**Permit Number: BCOM2405-0008**

**Description: 60 x 100 Enclosed Building for Tire Business (Storage)**

**Site Address: 918 LONGBRANCH RD**

4/30/2025	5/8/2025	5/14/2025	FIRE MARSHAL	Leslie Jackson	DISAPPROVED	See Notes
-----------	----------	-----------	--------------	----------------	-------------	-----------

Harnett County Department of Public Health Site Sketch

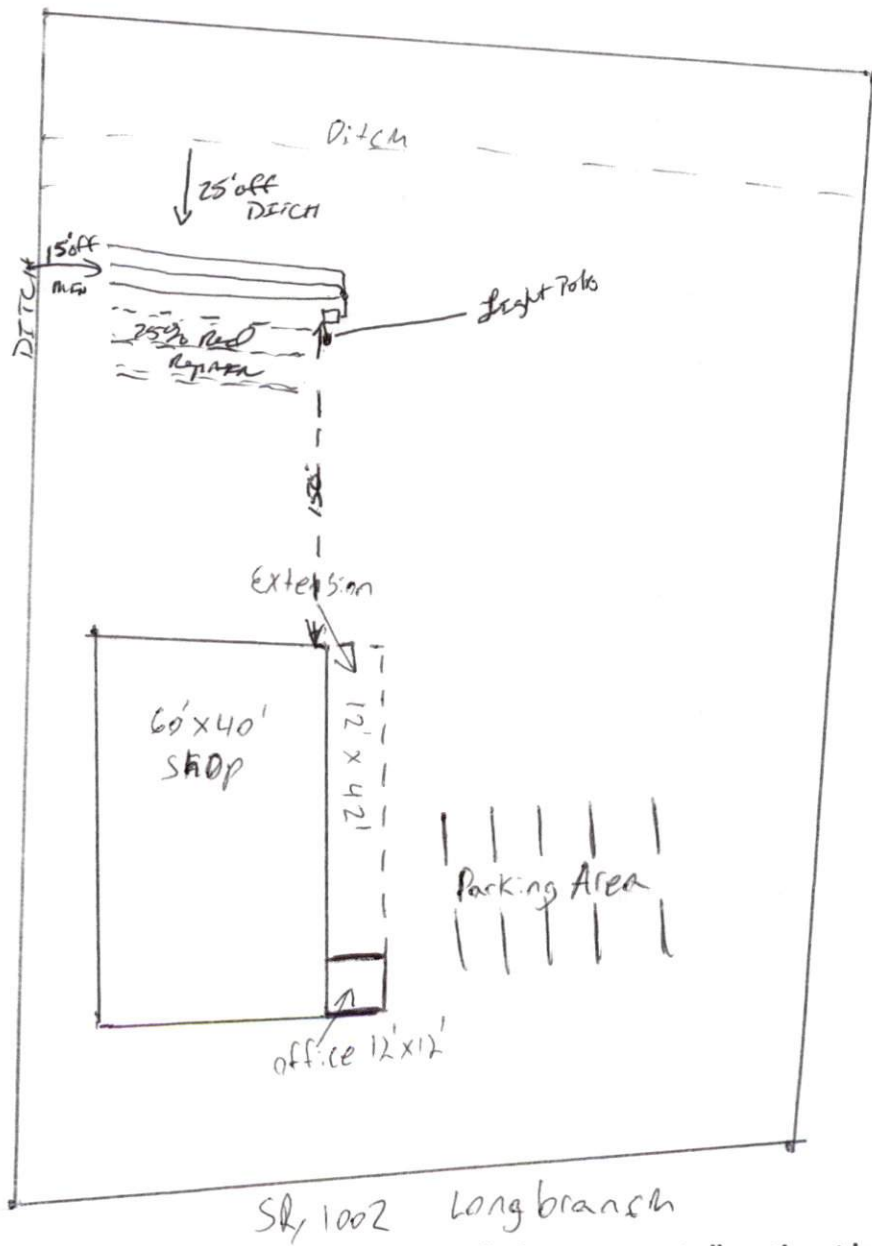
Site Comments:

- Show fire hydrant on plans. A fire hydrant will need to be installed no less than 400ft from the farthest back corner of the building. Fire hydrant will need to be installed on no less than a 6in water line. Contact Harnett Regional Water Department for more information.
- At least a 20ft all weather surface capable of holding 75,000lbs.
- Adequate turning radius for fire apparatus.
